**Recommendation Report for Planning Permission****REF NO:** EG/59/12/**LOCATION:** 17 Elm Grove South  
Barnham**PROPOSAL:** Laying of permeable hardstanding, A/C unit/enclosure, handrail and external lighting**SITE AND SURROUNDINGS**

| DESCRIPTION OF APPLICATION  | This application is retrospective to remove the front garden of the former school caretakers house, lay hardstanding to provide off street car parking. Also to provide an air conditioning unit, provide a ramp and handrail to the front of the building and to provide external lighting |

TITLE SITE PLAN

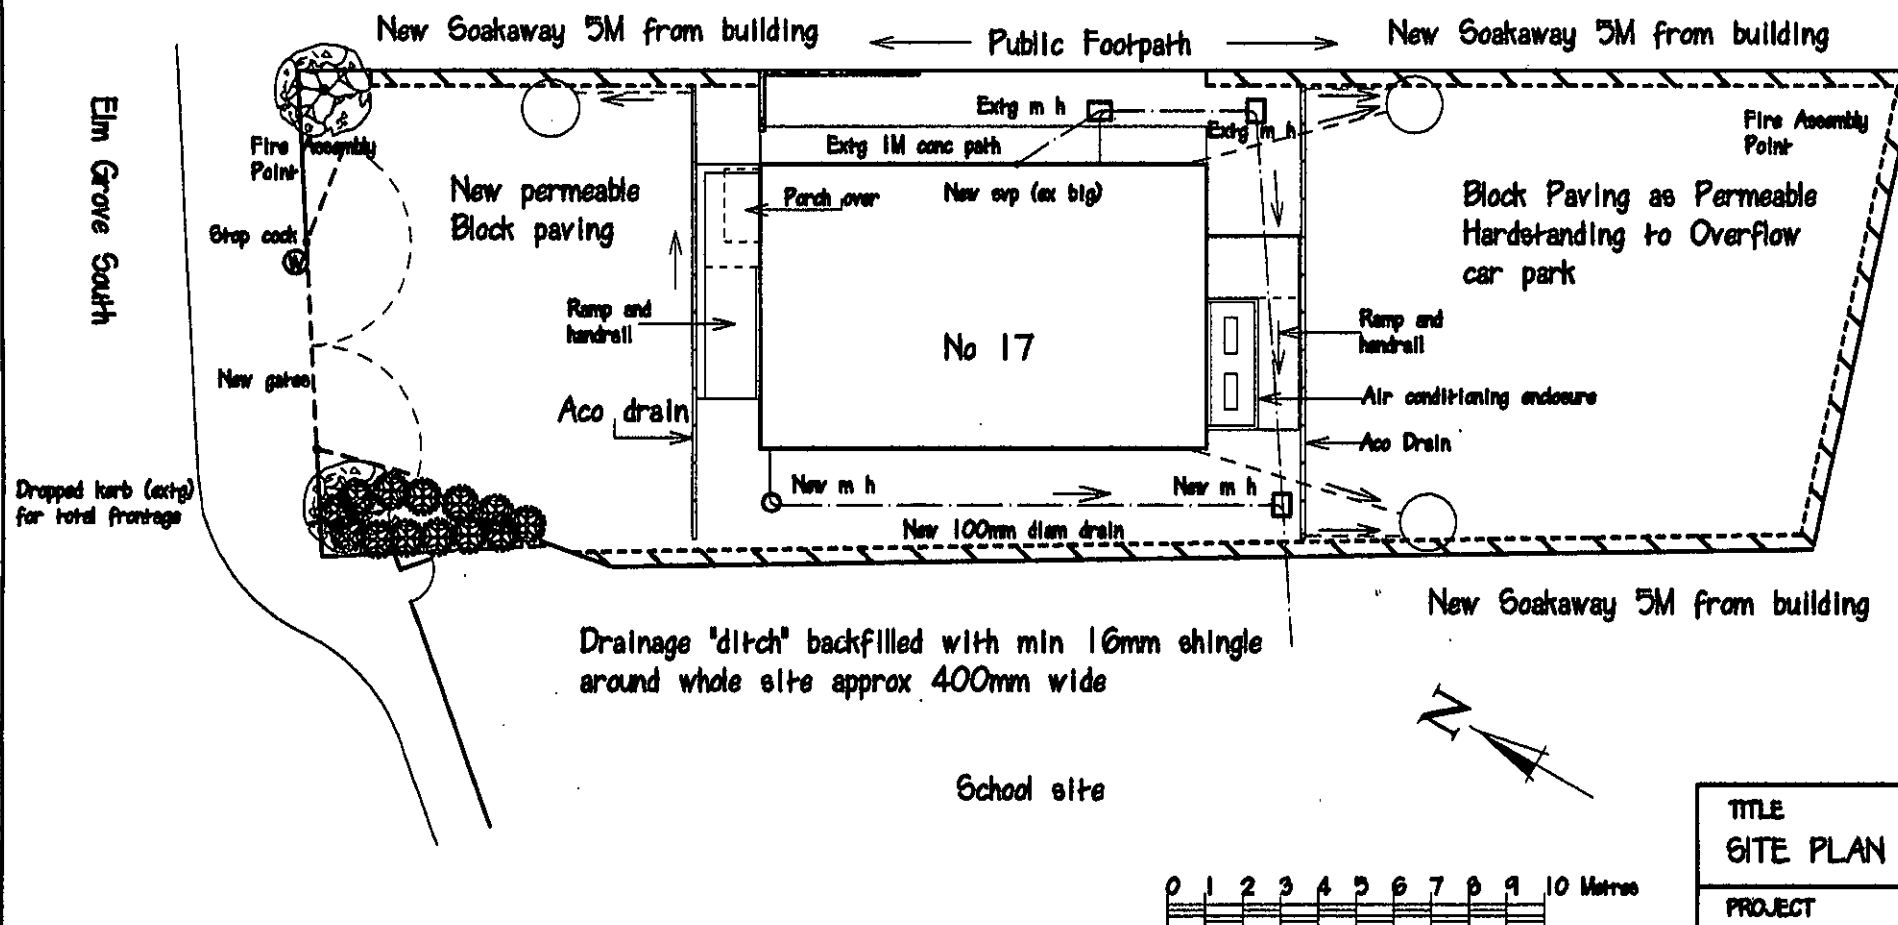
The proposal is considered to conflict with the relevant Development Plan policies in that the proposal has provided insufficient information with regard to the access and parking arrangements. This is due to the separation of the building from the planning unit of the school. The introduction of hard surfacing to the back and front of the property would be detrimental to the area of special character and would result in the loss of residential amenity.

The proposal will change the visual appearance within the street scene from a front garden with vegetation and planting, to a carpark covered entirely from back to front with hardstanding. The previous use was in conjunction with the school and the existing visual appearance provided a residential front garden in character with the surrounding area whilst being linked by pedestrian path to the school and chapel. This proposal would separate the link and separate the use. The site does not have an existing vehicular access, and the creation of a new dropped curb would further add to visual distraction. Additionally the increased parking demand, particularly on Sundays when the Catholic chapel at the school is in use, the hard landscaping would be a visual intrusion within the street scene which would be detrimental to this area of special character.

Insufficient details have been submitted with regards to noise from the air conditioning units with regard to the impact on the neighbouring properties. The proposed parking area being introduced to the front and rear would result in loss of visual amenity which would cause harm to the area of special character and neighbouring amenity.

- 2 The introduction of car parking and a area of significant hard surfacing to the front of the property would be out of character and would cause harm to the visual amenities of the Area of Special Character. The development would therefore be contrary to policies GEN7, AREA1 of the Arun District Local Plan.

- 3 The introduction of car parking to the rear of the site would cause undue disturbance to the amenity of the neighbouring residential property contrary to policy GEN7 of the Arun District Local Plan.

TITLE PROPOSED FLOOR PLAN (Ind Exits, Ramps & Air Con)	
PROJECT ELM GROVE SOUTH GOSPEL HALL BARNHAM PO22	
CLIENT BOGNOR GOSPEL HALL TRUST	
DRAWN SCALE DATE DRAWING NO AMENDMENTS	R HOLLANDS 1 : 100 @ A4 AUGUST 2012 12-08-GD-131-09A (A) Rear ramp revised

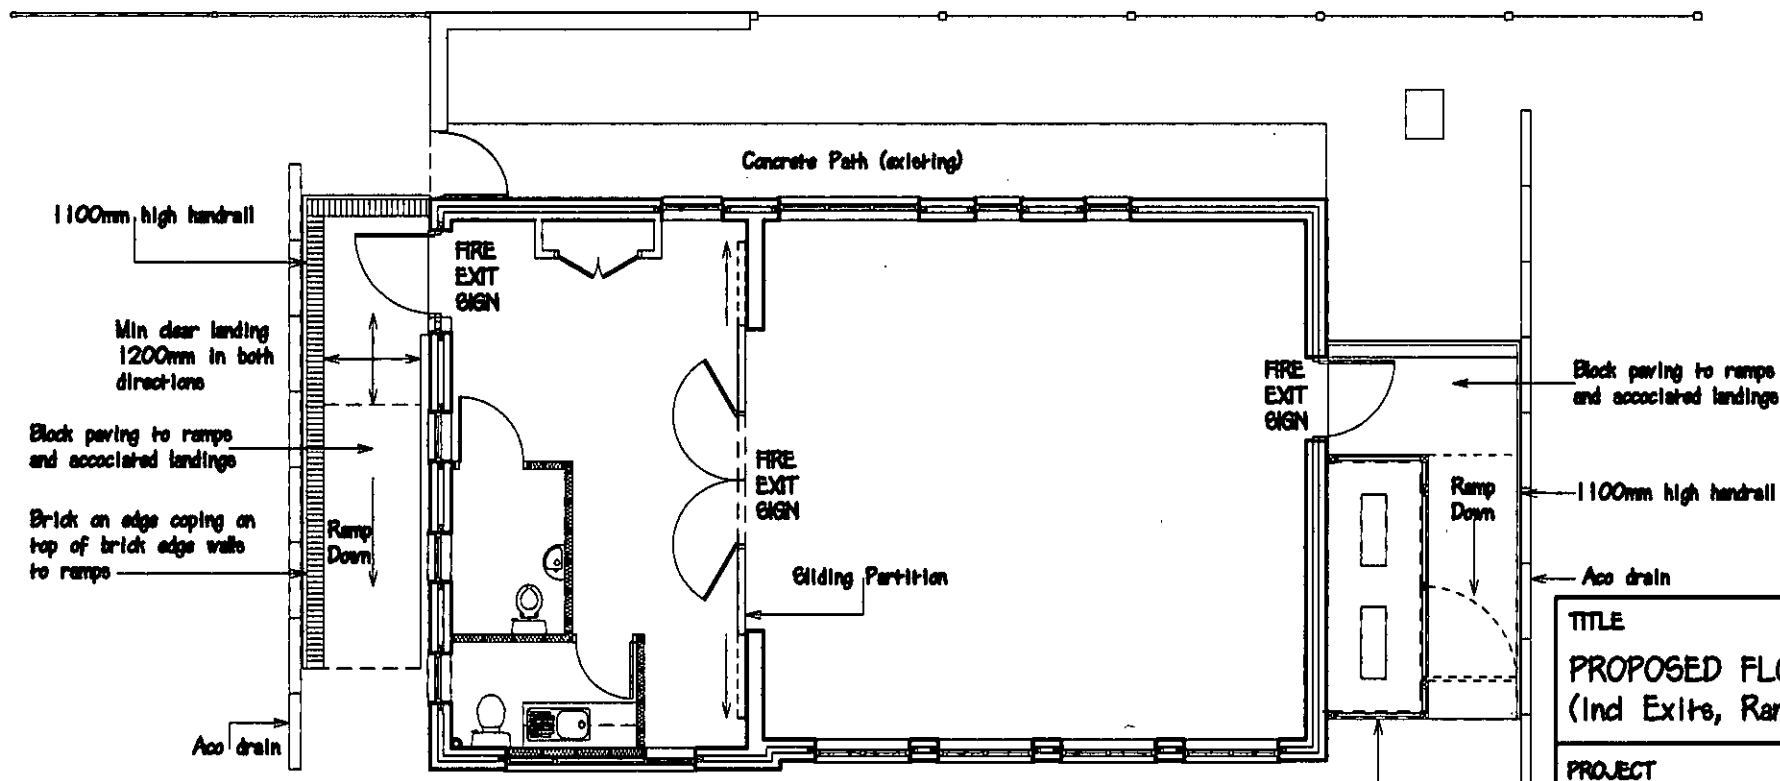
I note the fence surrounding the a/c units is described as "hit and miss" and assume that this will have gaps and therefore offer negligible noise reduction.

11 Sound data

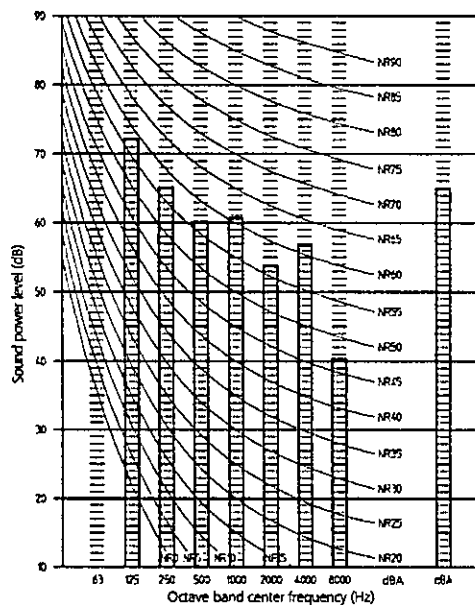
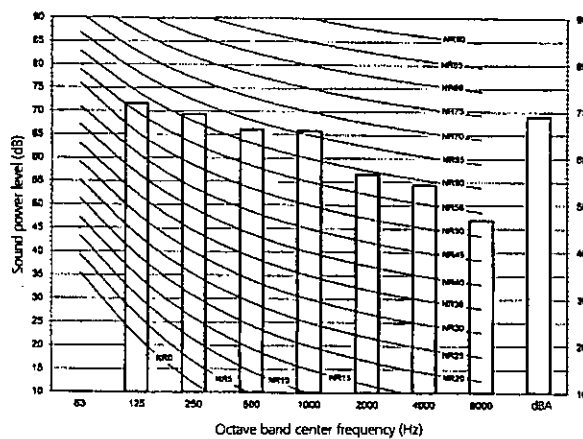
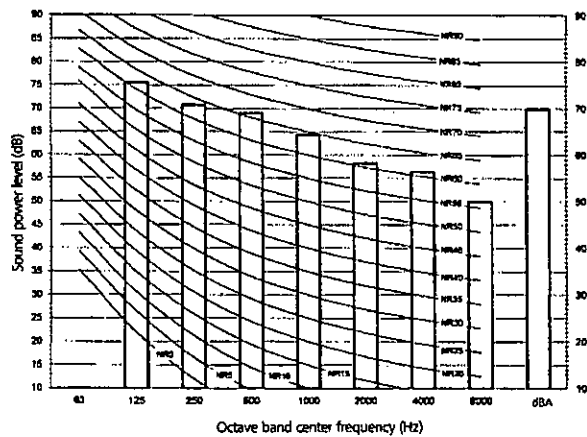
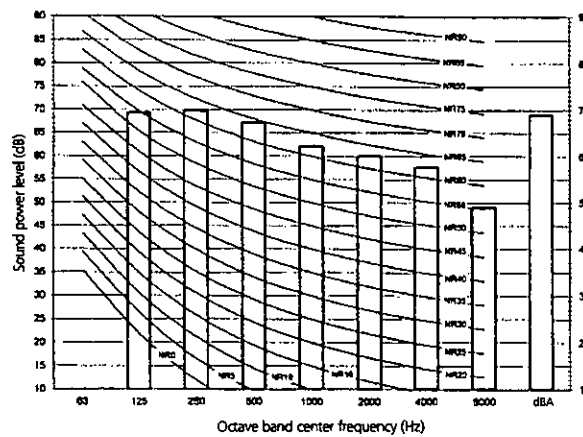
There is potential for noise affecting nearby residential premises. The information provided on sound power levels gives 3 sets of sound data, the first of which is significantly louder than the second two. It is unclear when the first set of sound power levels applies and under what circumstances. I would therefore object to the application unless further clarification is provided.
